DRB Application No.: 0700276
Project Name: Landscaping 21A TRUS
Agent: Alvin H. Hageman

Project # 1003121
Phone No.: 249.3378

14. Project # 1003121
07DRB-00276 Minor-Prelim&Final Plat
Approval

STEWART INGHAM agent(s) for ZIA TRUST INC request(s) the above action(s) for all or any portion of Tract(s) 19, M.R.G.C.D. MAP 36 (to be known as **TRACTS A & B, LANDS OF ZIA TRUST**) zoned R-1 located on FORAKER NW between LOS TOMASES NW and 8TH ST NW containing approximately 1 acre(s). [REF: 07 DRB00135] (H-14) **THE PRELIMINARY AND FINAL PLAT WAS APPROVED WITH FINAL SIGN-OFF DELEGATED TO UTILITIES DEVELOPMENT TO ADD BENEFICIARY AND MAINTENANCE LANGUAGE FOR PRIVATE WATER AND SEWER SERVICE LINES AND ACCESS EASEMENT AND TO PLANNING FOR AGIS DXF FILE AND TO RECORD.**

PURPOSE OF PLAT:

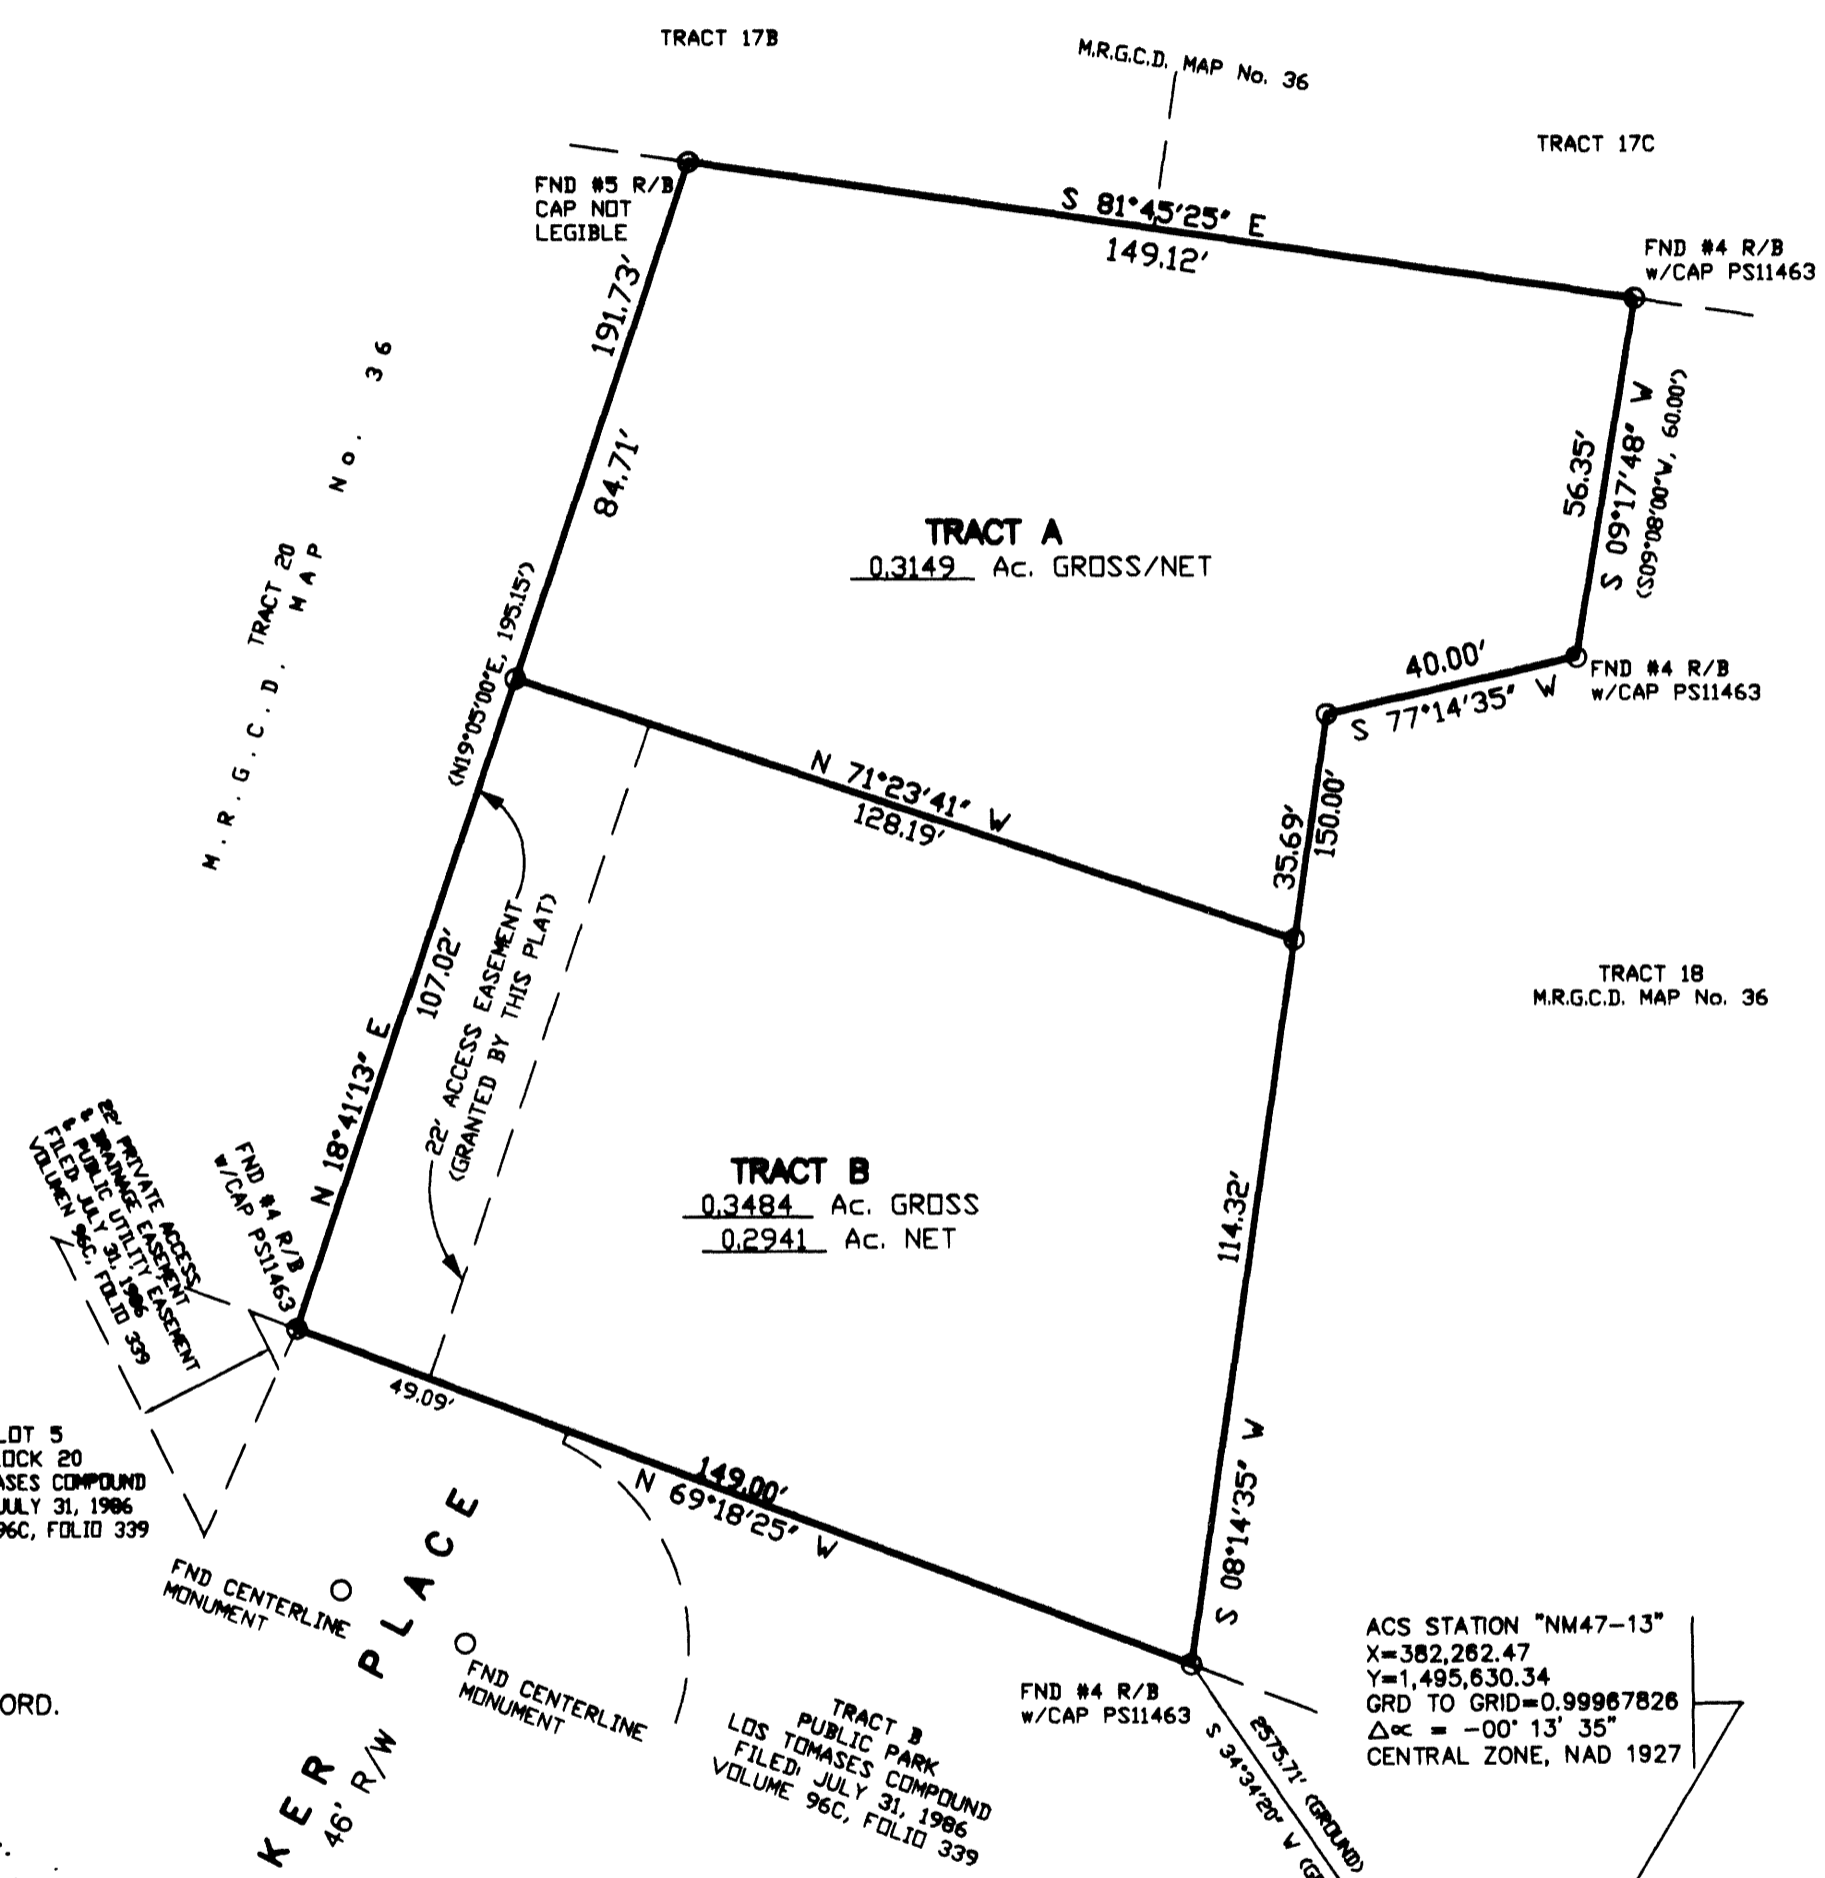
UTILITIES: add beneficiaries & Maintenance language for private water/sewer service lines and access easement

A cross lot drainage easement is required.

AGIS dxf is not approved.

<u>No.</u>	<u>Comment</u>
1)	A copy of the 22' private access easement is needed.
2)	A copy of the plat to the south is also needed.
3)	Is there a drivepad on the Foraker cul-de-sac?
